From: Ford , Sarah
Sent: 13 March 2018 12:00
To: DevelopmentControl & DevelopmentManagement
Cc: Catling , Rik
Subject: RE: 2017/1718 Planning Consultation

PROW response as follows

APPLICATION NO: 2017/1718
DESCRIPTION: Residential development for up to 85 dwellings with associated infrastructure and access (Outline with All Matters Reserved apart from access)
LOCATION: Former William Freeman Site, Wakefield Road, Mapplewell, Barnsley, S75 6DN

Drainage Strategy

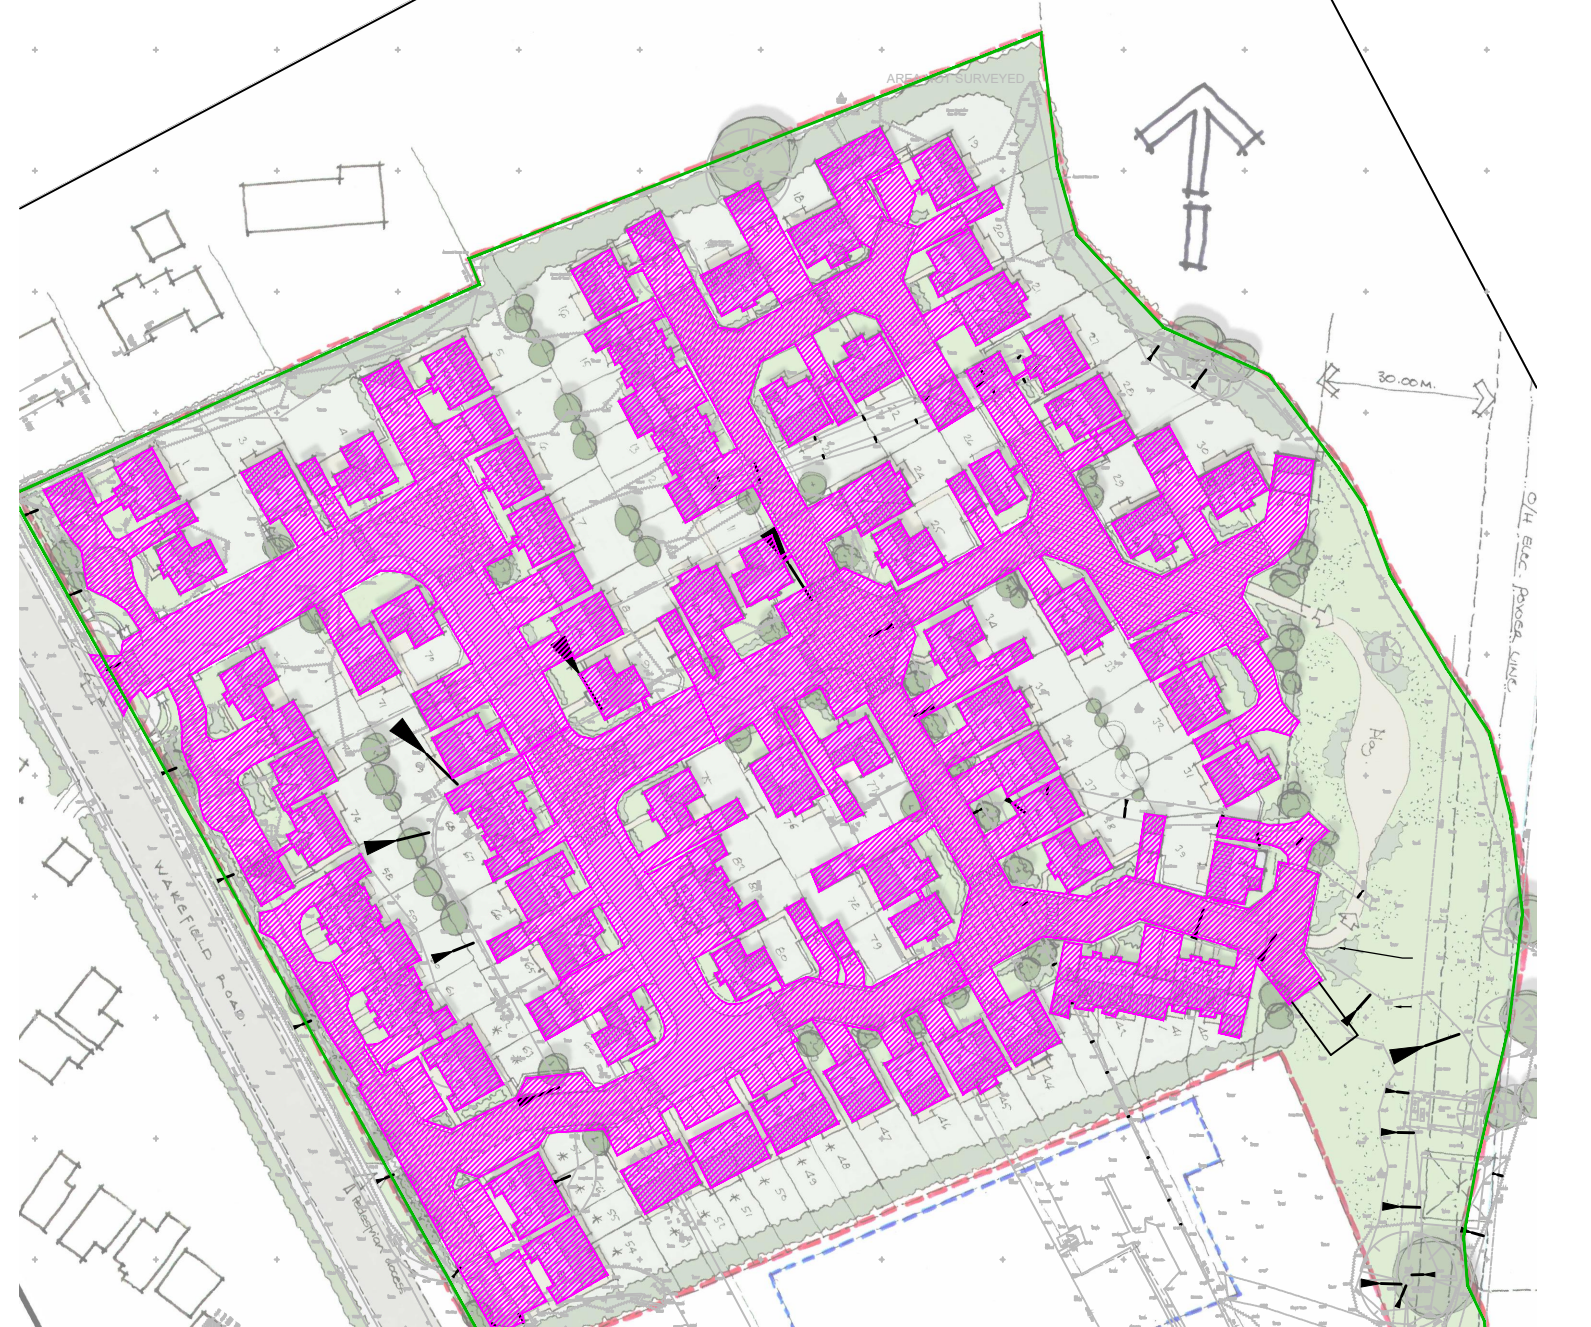
My main concern is the SUDS proposal to soak away along the eastern boundary. We already have a major drainage problem of water in the dismantled railway line cutting making the footpath unusable. The water is coming from the surrounding land on both sides and any more soakaways will make matters worse unless action is taken as part of the development to resolve that problem. However I understand that the vast majority of water comes from the current use of the site where they were given permission for a single pipe to drain into the cutting. So if this development replaces that system the remains of original drainage underneath the A61 might handle the seepage from the rest of the land.
